Strategic Drainage Consultation

Consultation on Application Number: 2017/90620

Address: Dobroyd Mills, Hepworth Road, New Mill, Holmfirth, HD9 1AF

Proposal: Planning permission for demolition of existing buildings, change of use of existing building to mixed uses comprising B1a (offices), B1c (light industrial), A3 (food and drink) and C3 (up to 18 dwellings) and outline permission for erection of 75 dwellings

Drawing 2009-2009 - Rev A
Indicative Site Sections for the
residential and mixed use
redevelopment of
Dobroyd Mills,
Hepworth / Jackson Bridge

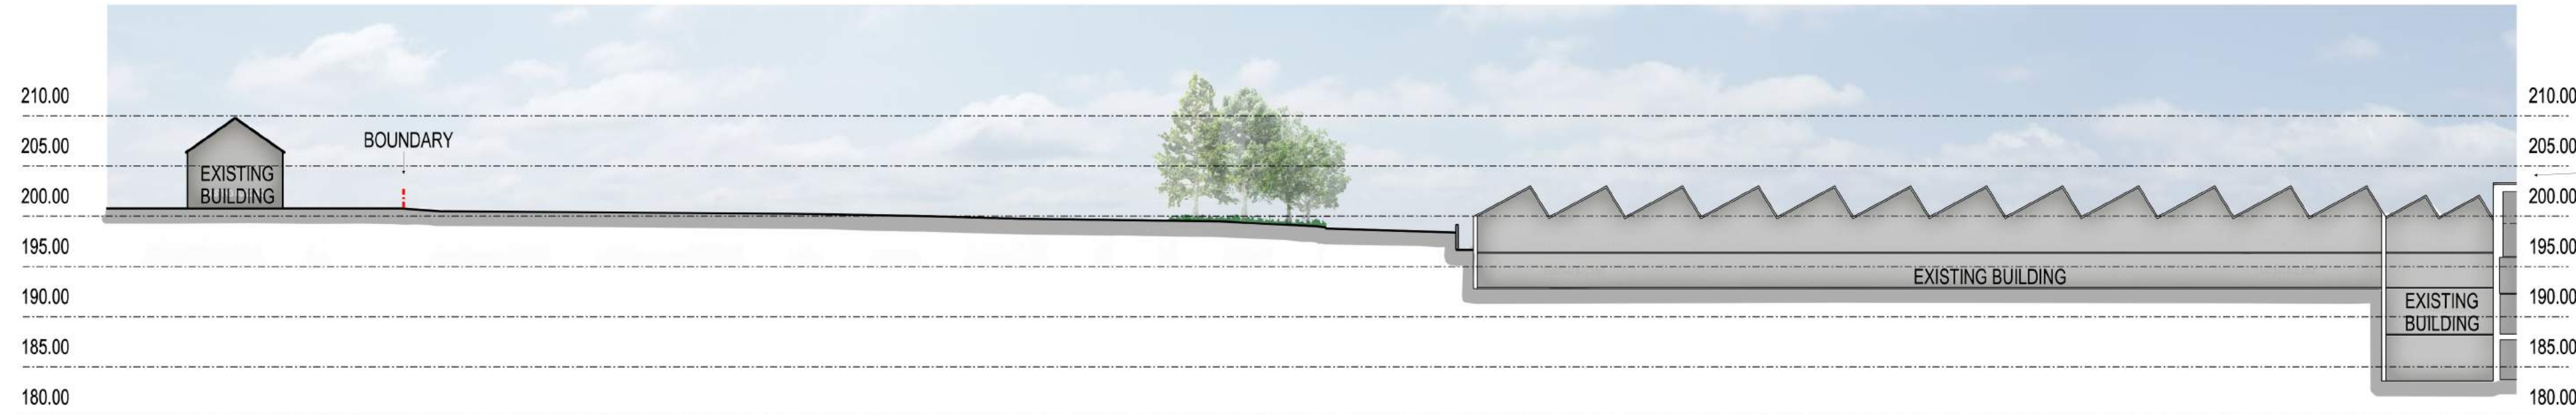
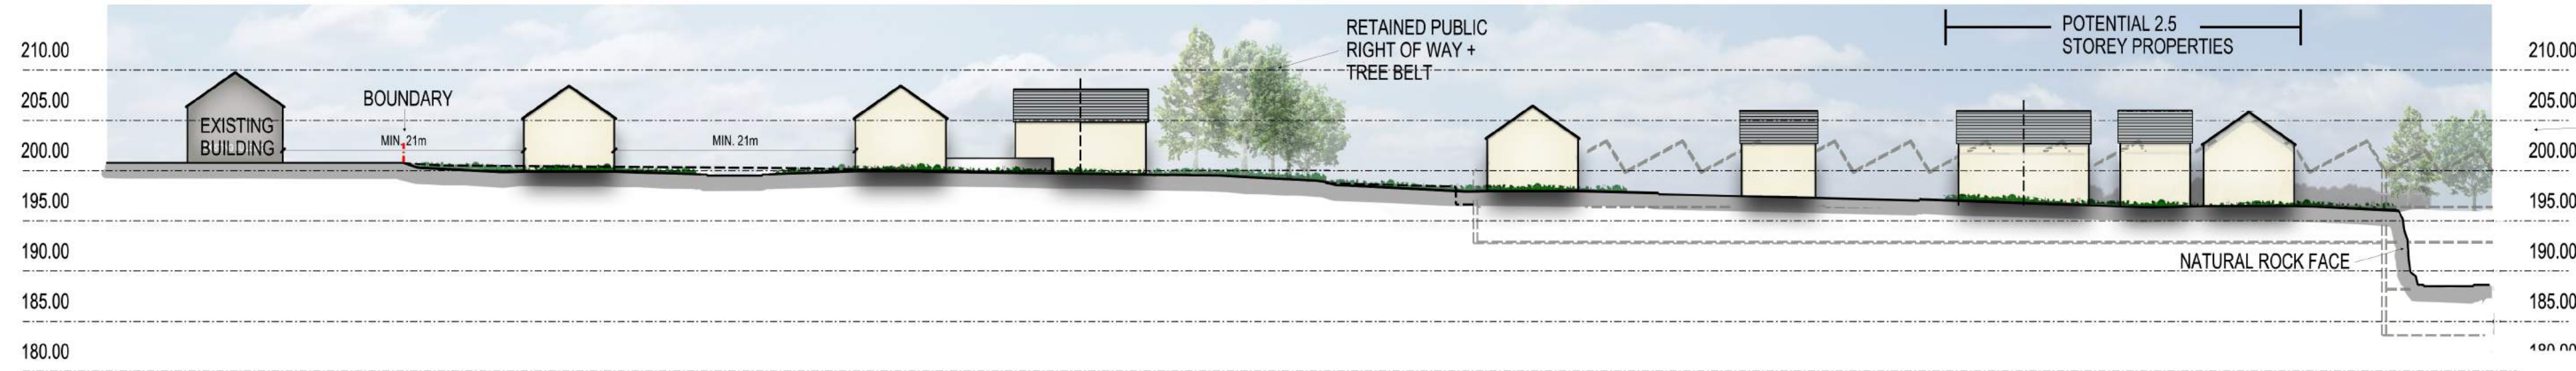
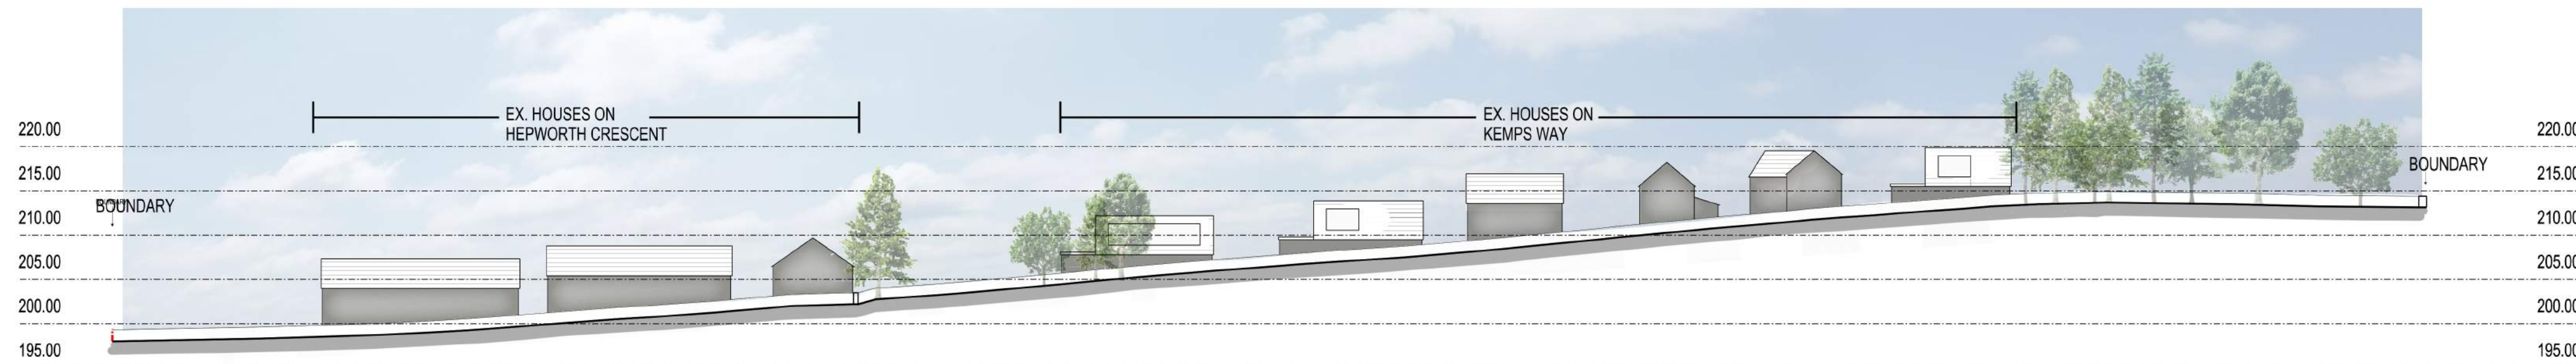
A revised layout and topography has been supplied. A narrative on flood routing is required to ensure a design has been submitted that utilises road network and public open space for overland routes, and protects property and curtilage. No evidence has been submitted that this has been considered.

For surface water exceedance events and blockage scenarios we are concerned that properties should not be located in low spots and that road networks and public open spaces are used to convey water safely off site. There is no evidence that this has been taken into account in the indicative road layout to date.

Title
FLOOD MODEL DRAWING

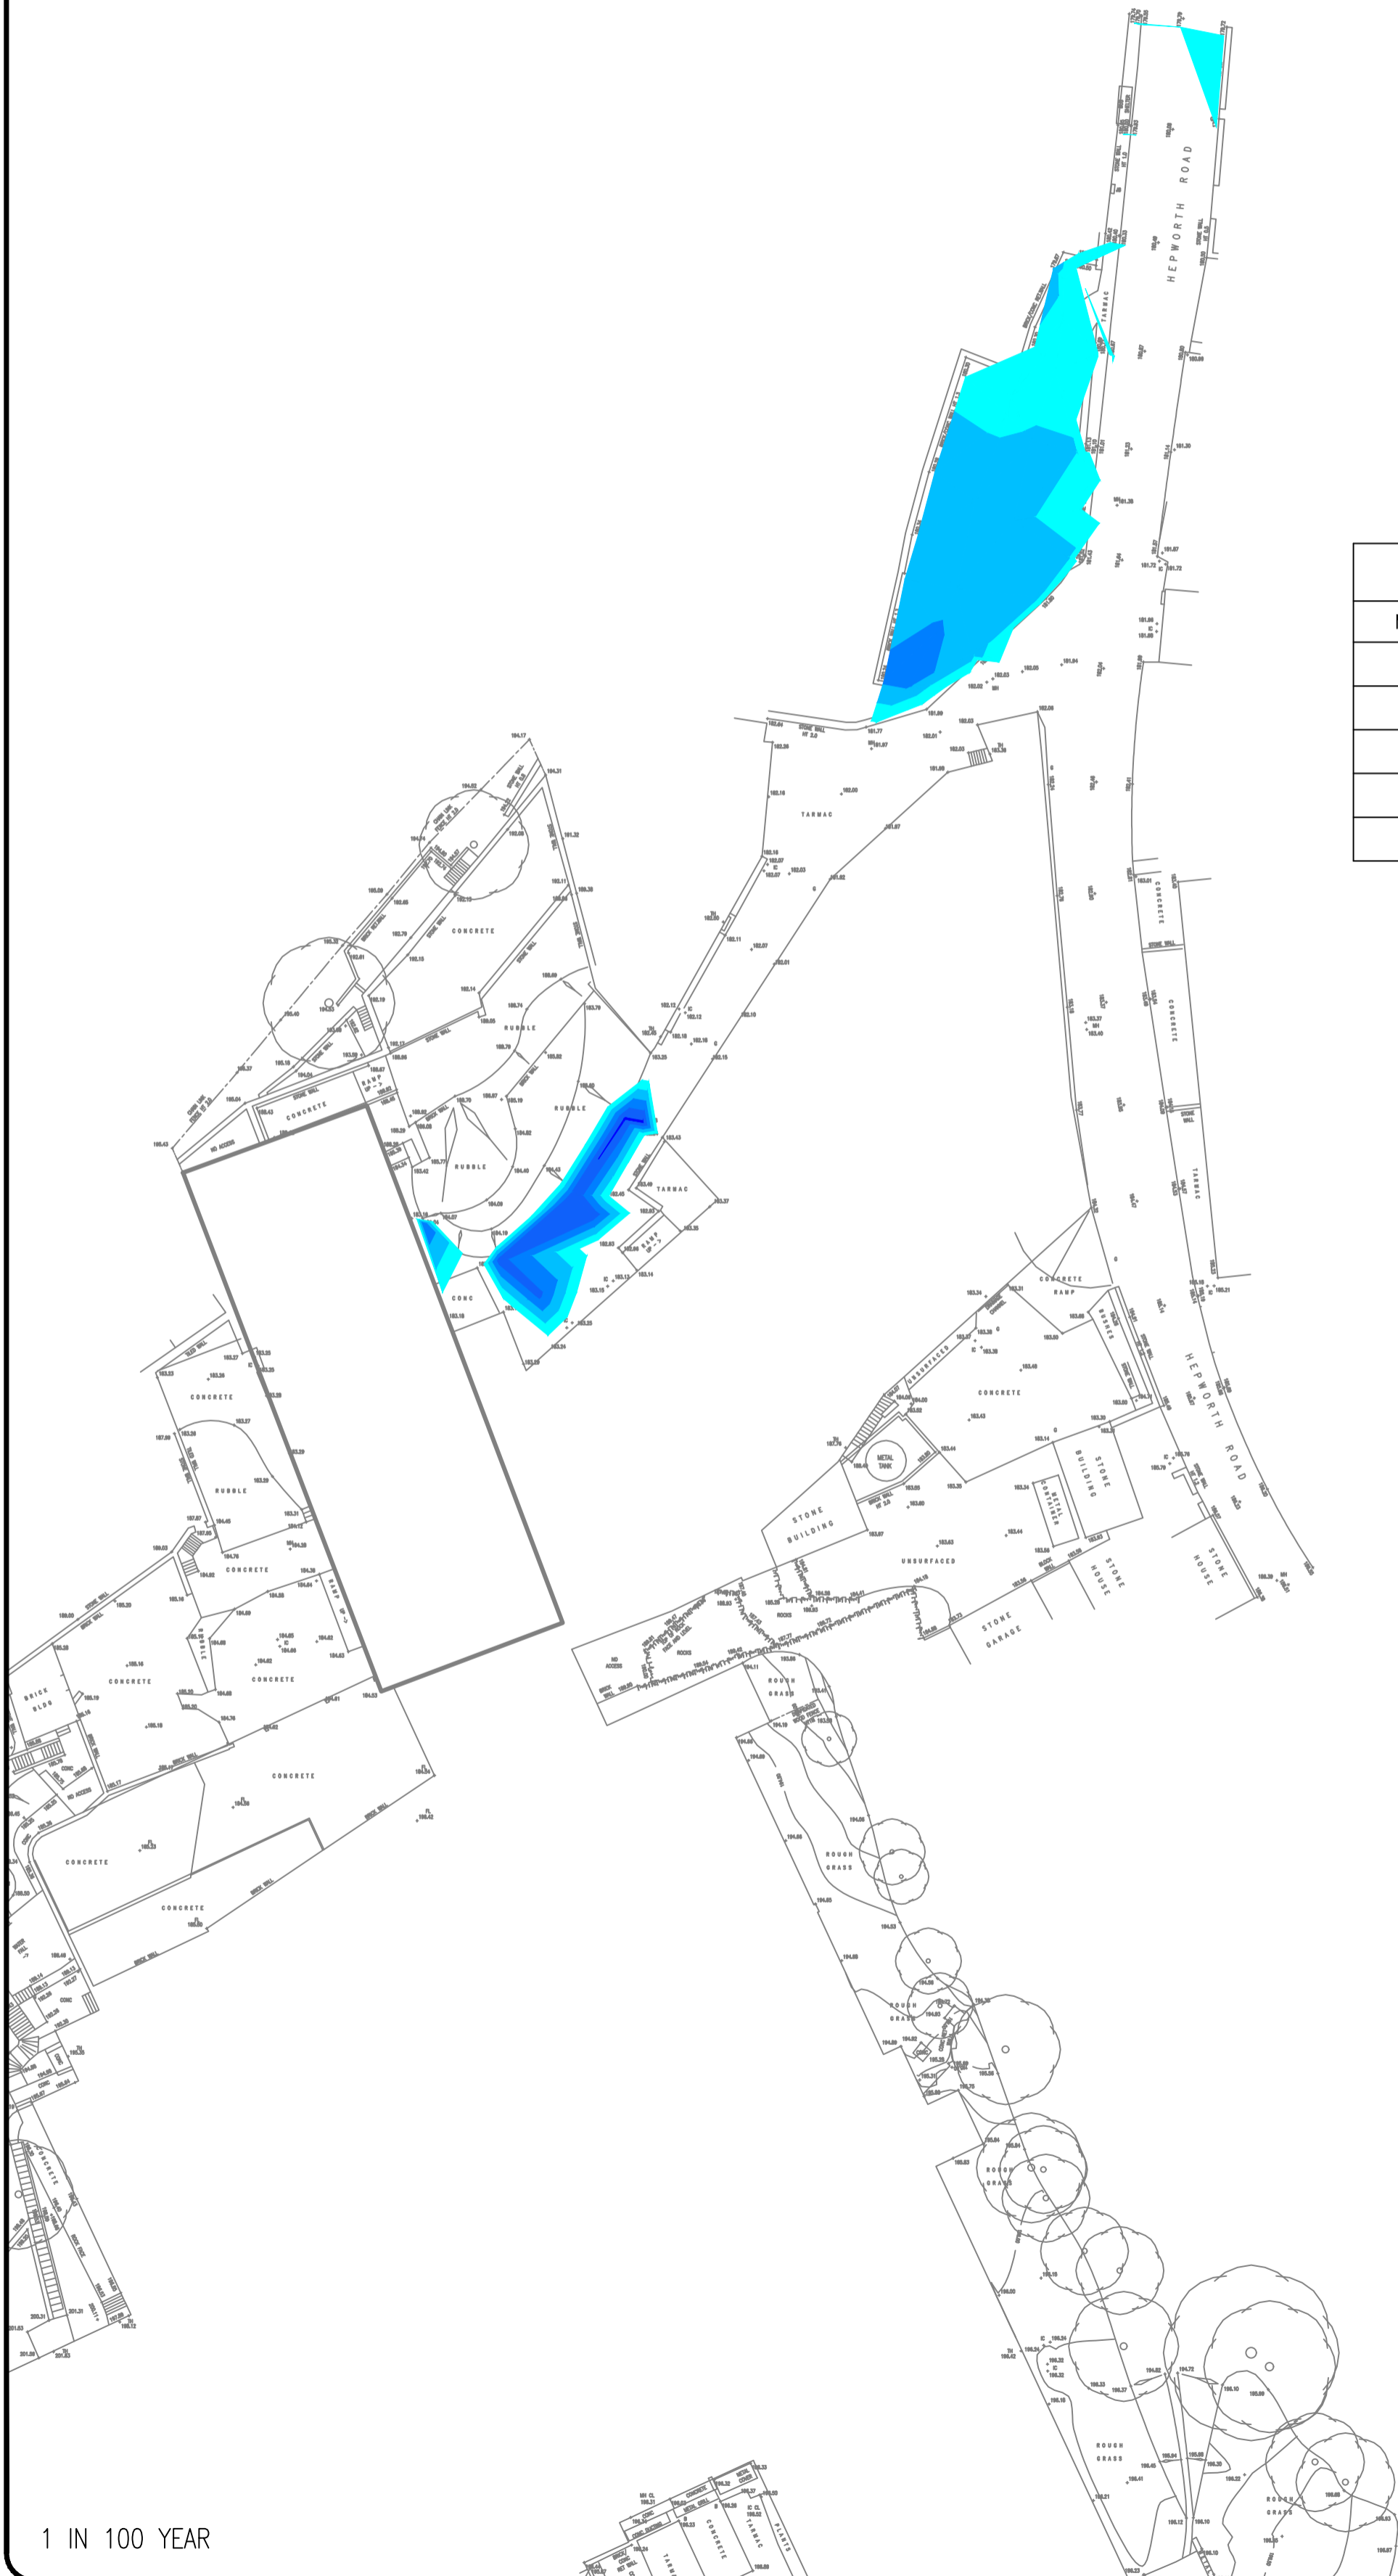
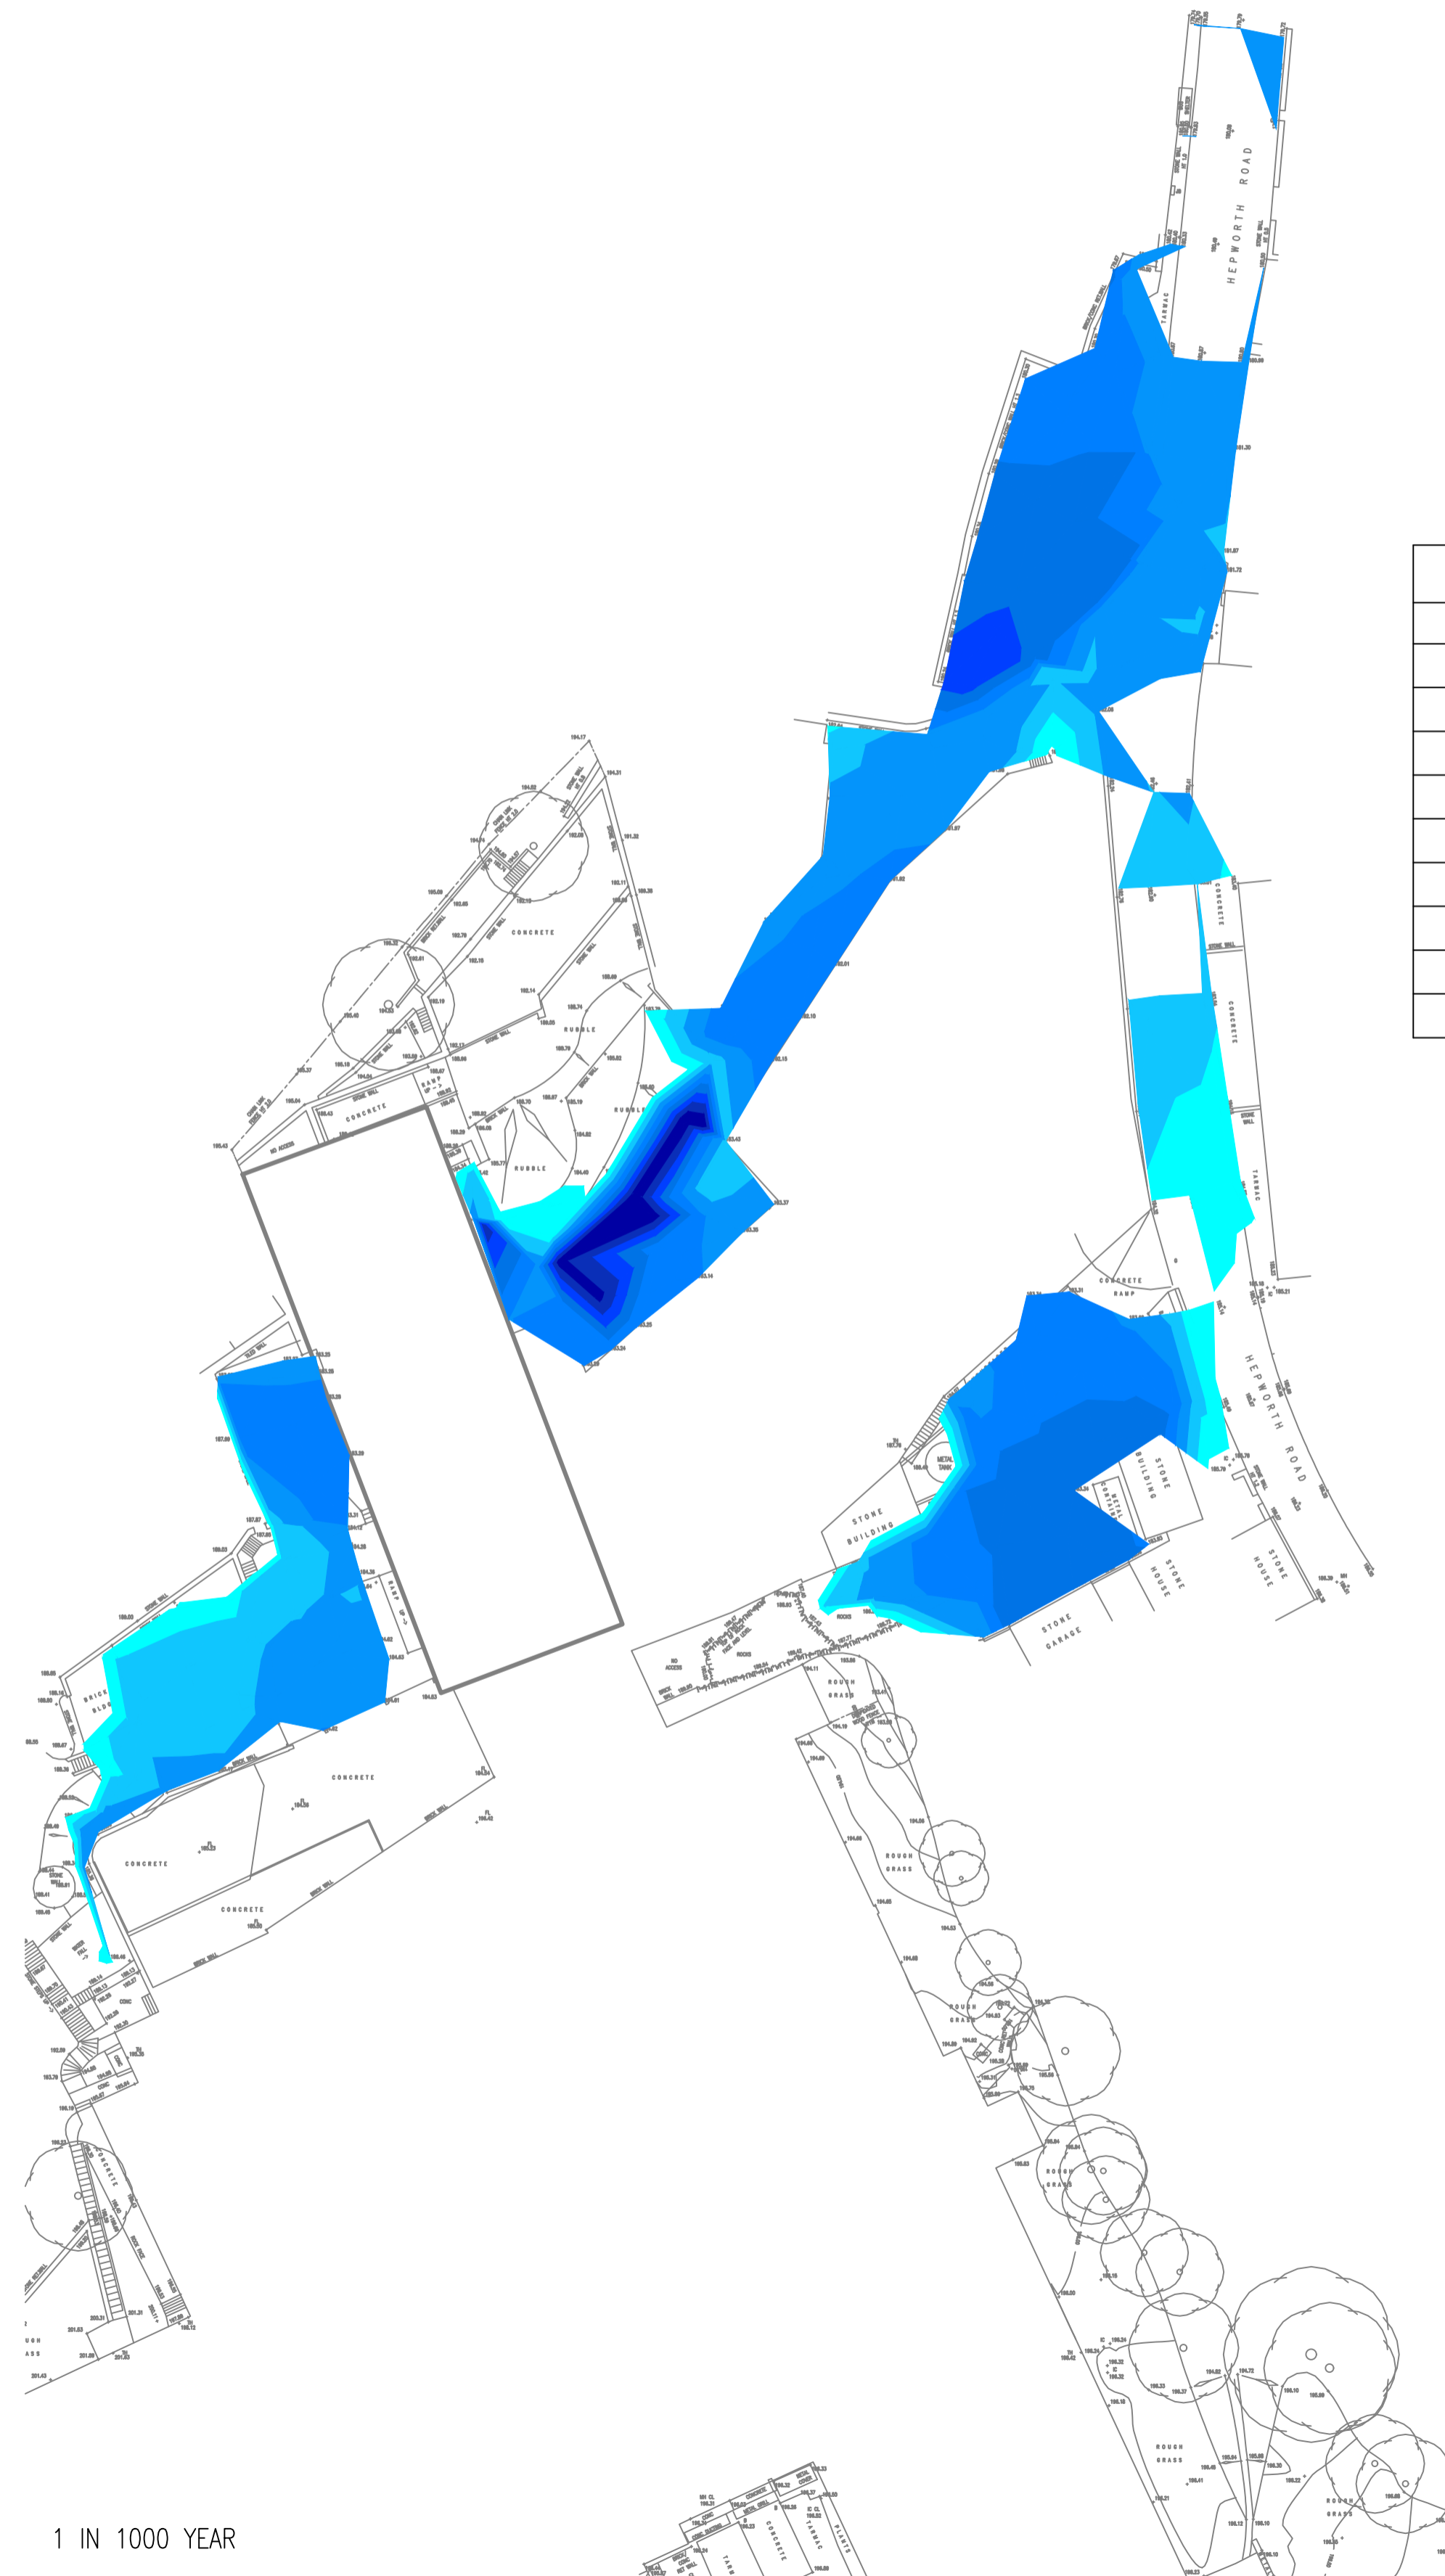
The Environment Agency should comment on main river flood risk with regard to the existing building to be retained, the uses proposed and their acceptability and whether safe access and egress can be maintained.
